**Planning Application Ref:** AB/88/19/PL

**Location:** Land at Electricity Sub Station, Ford Road, Arundel, BN18 9DX

**Description of works:** 38no. residential apartments (9 No 1-bed units & 29 No. 2-bed units) along with access, off-street parking, amenity space & enhancements to the local footpath network

COMBINED TREE RETENTION/REMOVAL AND PROTECTION PLAN

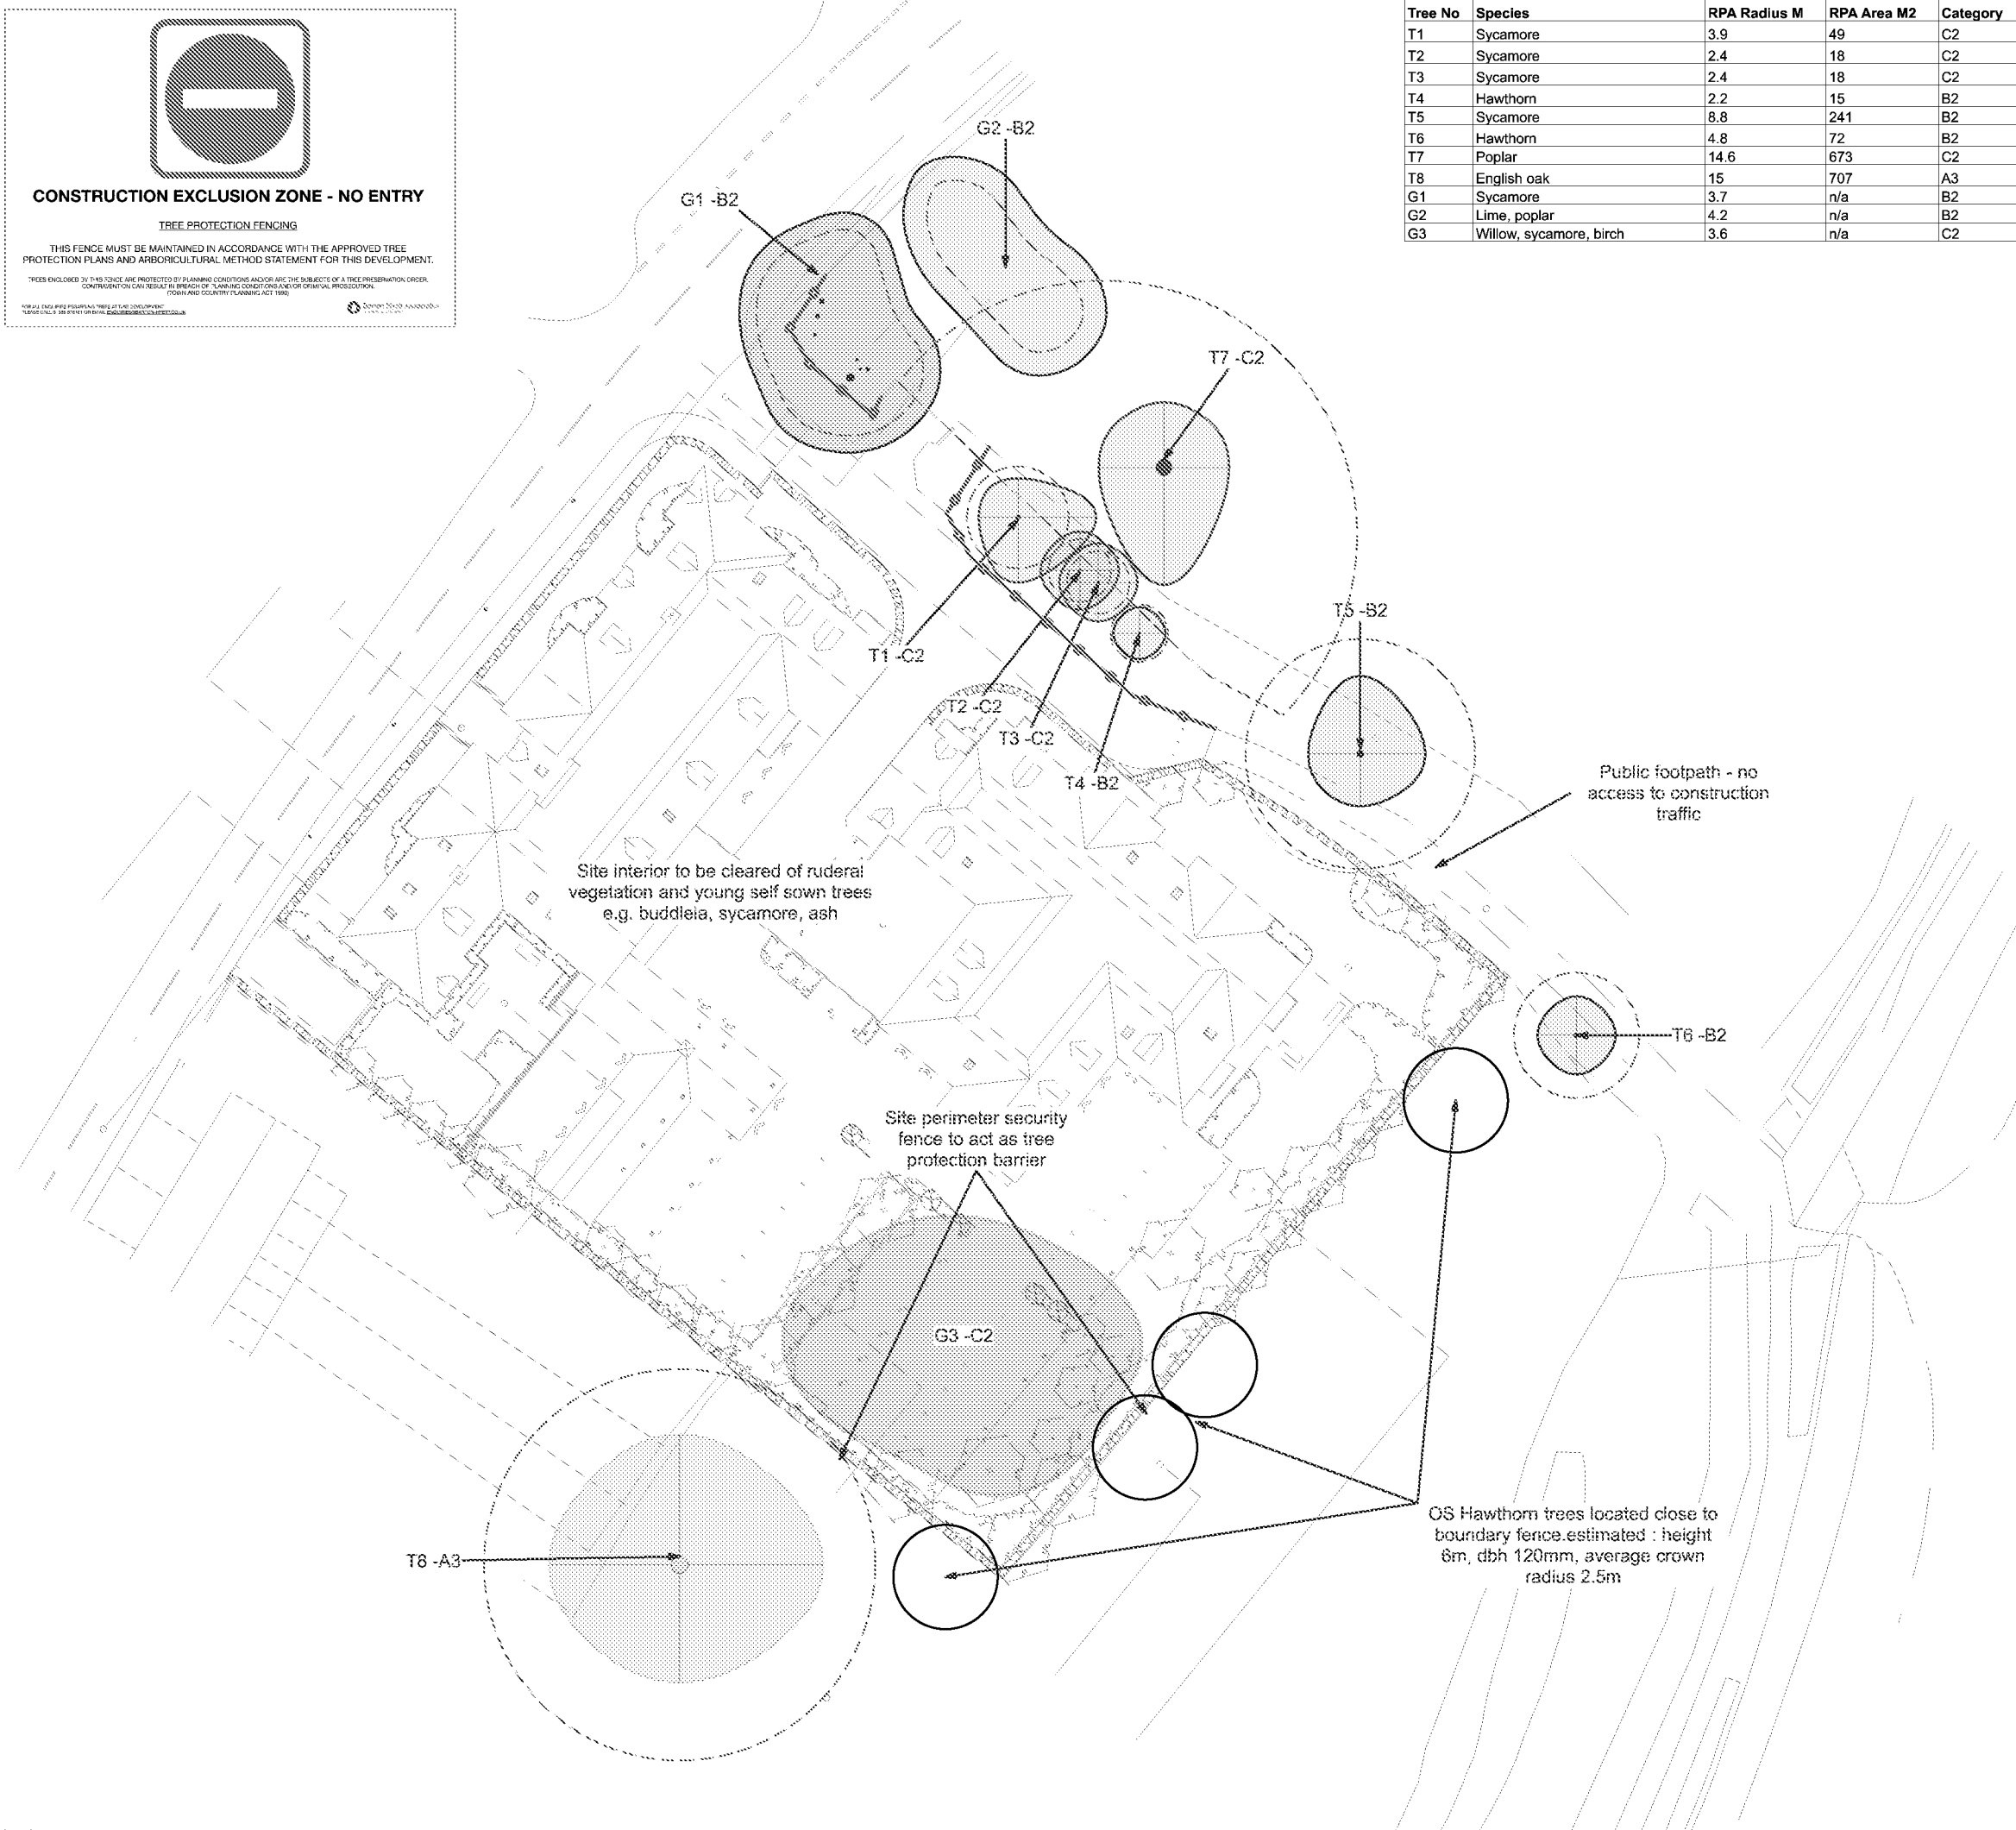
- **I recommend the above scheme for APPROVAL, subject to the following conditions being applied:**
  1. Before the site is occupied or any machinery is introduced to the site or demolition work or construction work or alterations to existing ground levels takes place the Arboricultural Expert representing the site owner(s) will provide the local planning authority with a brief report and photographic evidence to demonstrate that all protective fencing has been inspected to verify it is 'Fit for Purpose' as required under British Standard 5837:2012 and has been erected and positioned exactly as shown on the **Tree Retention/Removal & Protection Plan, dwg.no. BHA\_363\_02, dated 23/05/2019.**

- 
2. All activity at the site is to be carried out in strict accordance with: - **Arboricultural Survey, Impact Assessment and Protection Plan, ref. O.2588, May 2019.**
    - Prior to any works associated with the planned enhancement of footway link bisecting the root protection area of T05 sycamore, a Method Statement prepared by an Arboricultural Expert must be submitted that stipulates how this can be achieved without adverse impact on tree roots. Written approval and confirmation of acceptance of this Methodology must be issued before any works are commenced out on site.
    - If there is deemed to be a need for any Utility Service Route connections to bisect retained tree Root Protection Areas/Zones, then prior to their installation a Method Statement prepared by an Arboricultural Expert must be
